Application No: BE/104/21/PL
Site Address: Land Adjoining the Tesco Express 351 Chichester Road Bognor Regis PO21 5AN
Description of works: Erection of 7 No. 2-storey dwellings consisting of 3 No. 2 bed units & 4 No. 3 bed units, access, parking, cycle storage, bin store and other associated landscape works. This site is in CIL Zone 4 & is CIL Liable as new dwellings.

Thank you for your internet representation made on 25th July 2021 which has been recorded as an objection with the comments as follows:

4 Garden Elevation
1 : 50

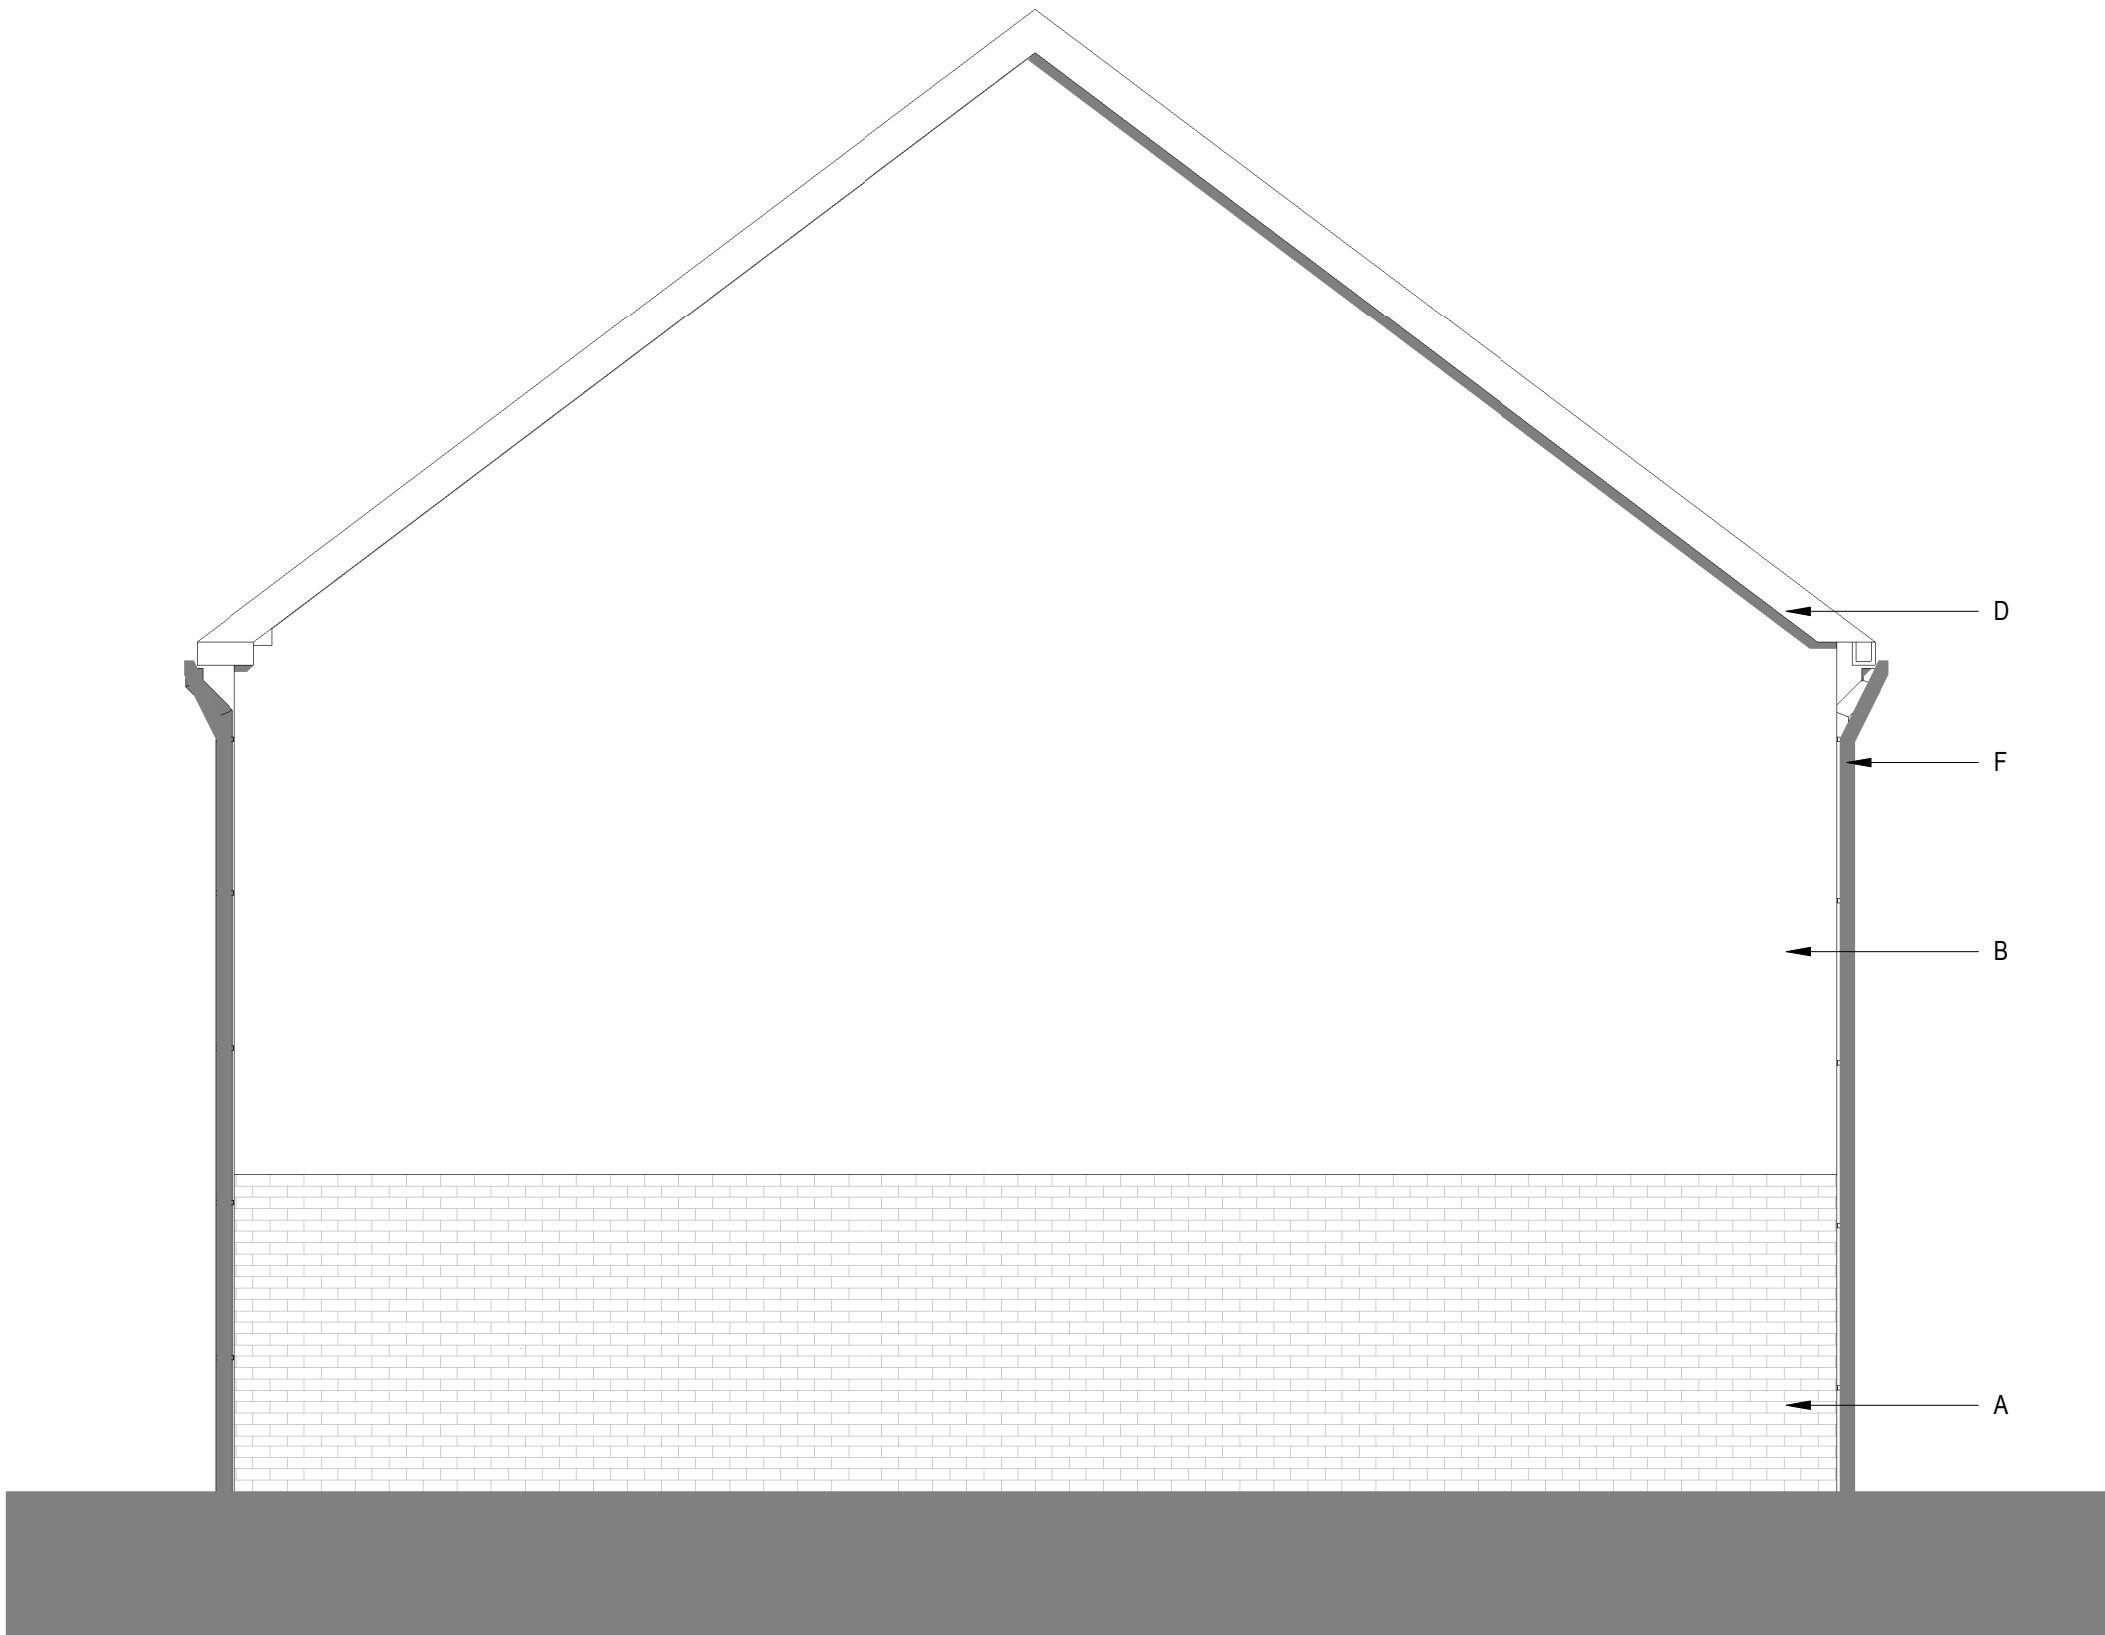
My garden will be overlooked by the rear windows of Block B.
